CITY OF PORTLAND, MAINE
DEVELOPMENT REVIEW APPLICATION
PLANNING DEPARTMENT PROCESSING FORM

2007-0204
 Application I. D. Number
11/29/2007
 Application Date
Single Family Home
 Project Name/Description

Victor Rd , Portland, Maine
 Address of Proposed Site
159 D025001
 Assessor's Reference: Chart-Block-Lot

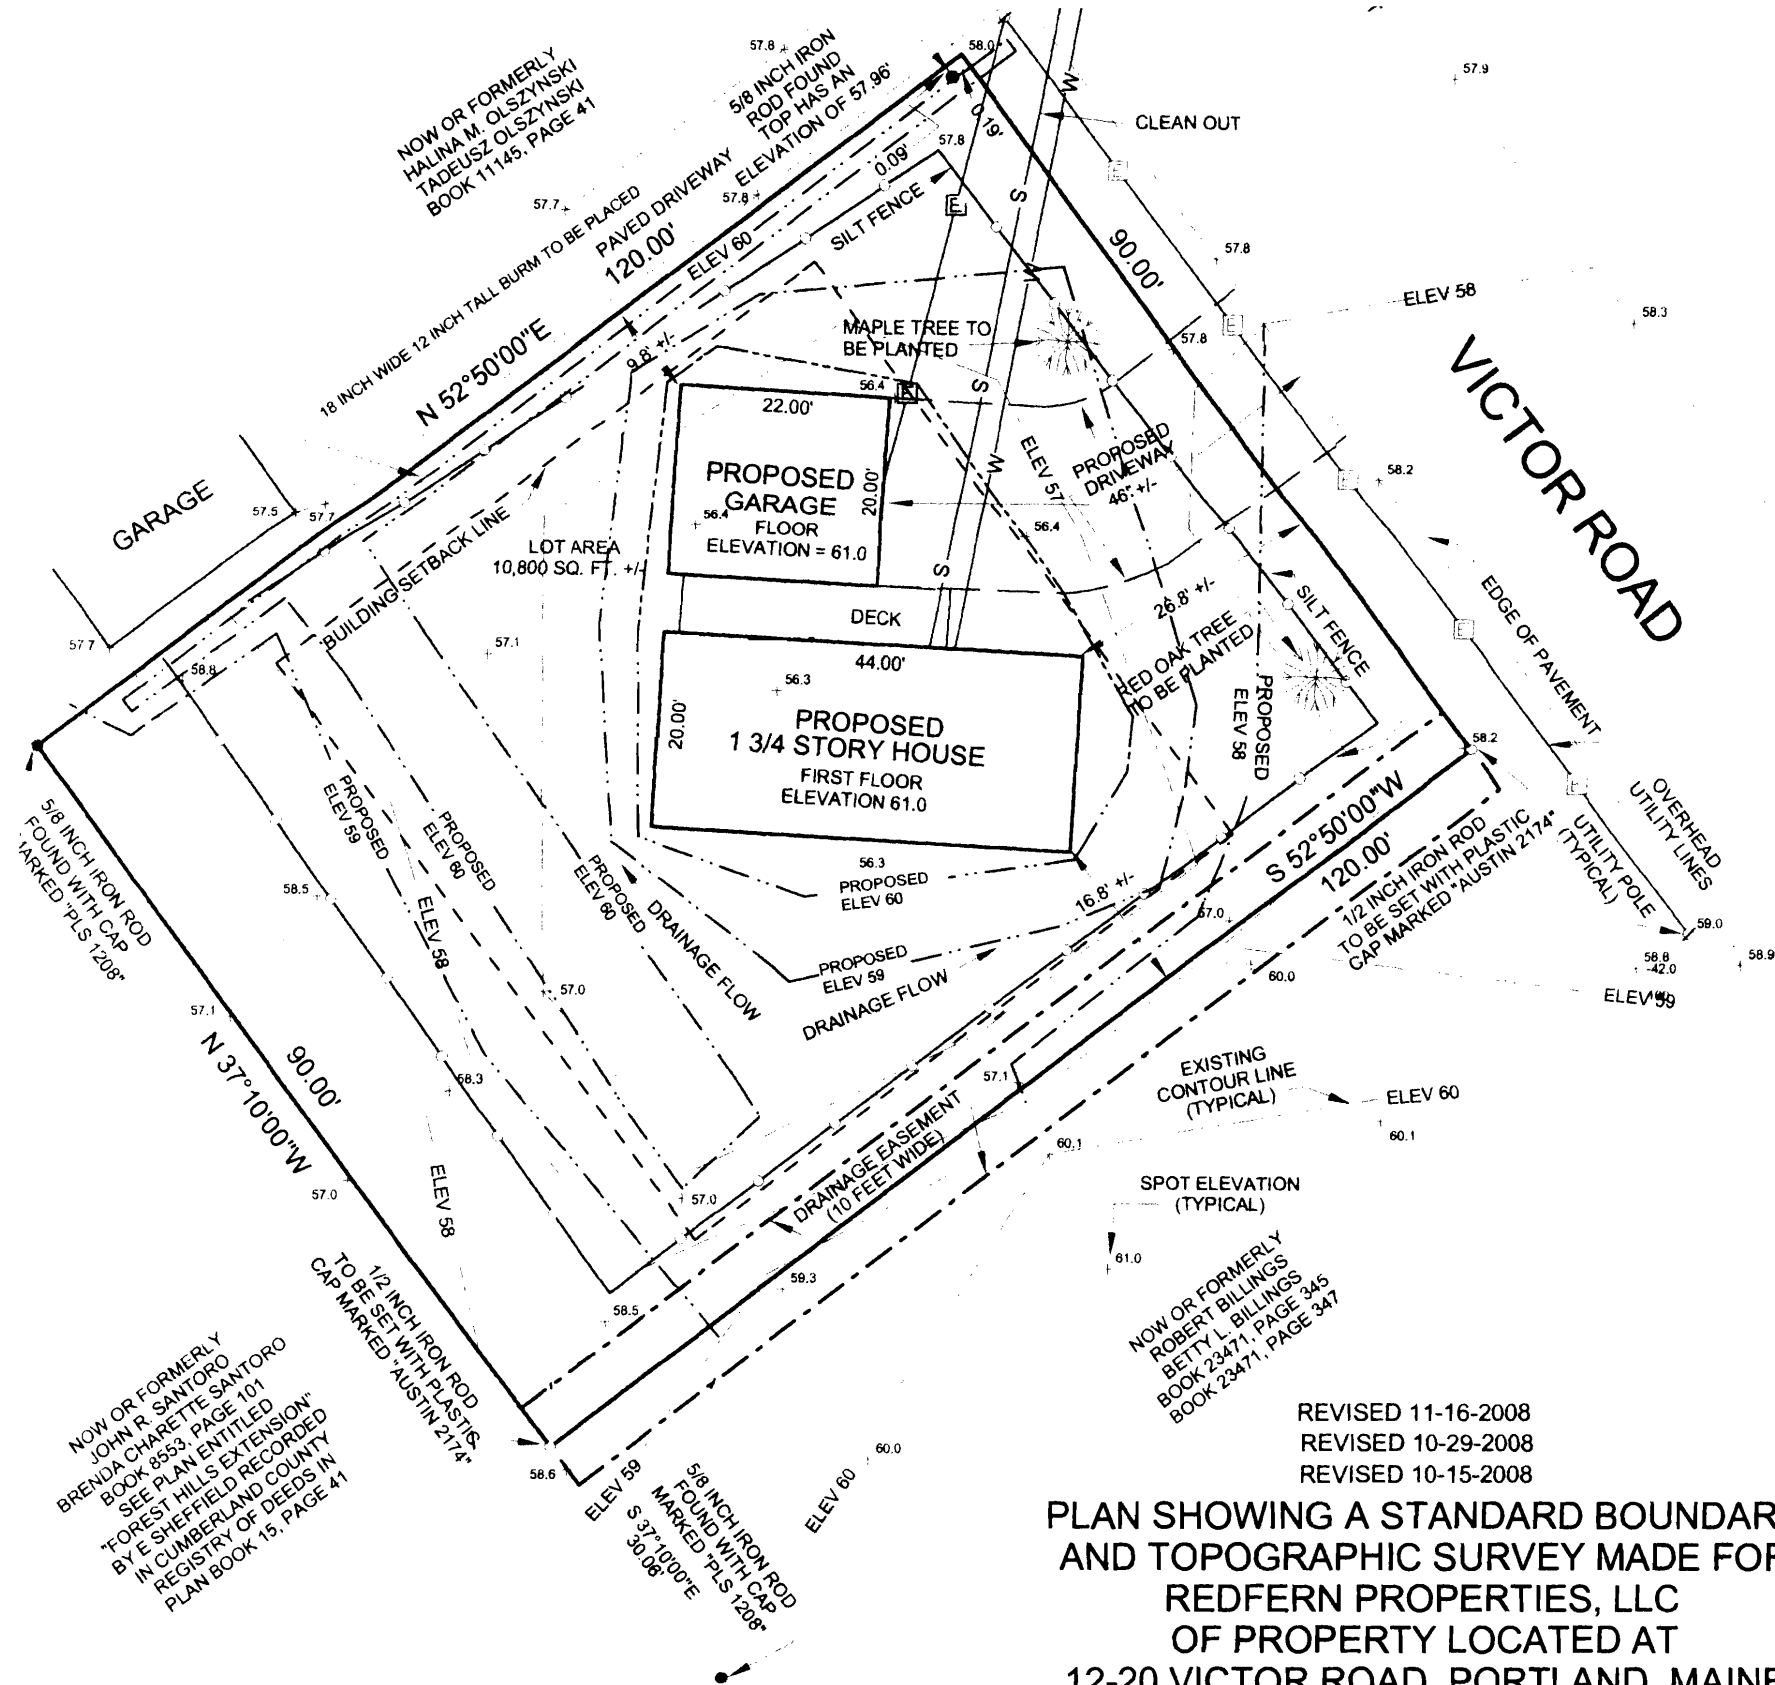
check for wetlands - show on survey & any amount of filling
- Survey ERP 3 - see plan note
- show silt fence/ECM, utilities
- show 2 street trees
- show proposed contours & drainage patterns

It was nice to meet you last week, and thank you for taking the time to tell me how to make the necessary revisions to the survey for the planned new single family residence at 12 Victor Road in Portland. I have enclosed four copies of a revised survey which include the location of erosion controls, the location of the proposed utilities, the locations of two street trees, and a revised grading plan showing the contours of the proposed elevations. I have also enclosed copies of the Tier 1 wetland permit issued by the Maine Department of Environmental Protection and the authorization letter from the Army Corps of Engineers.
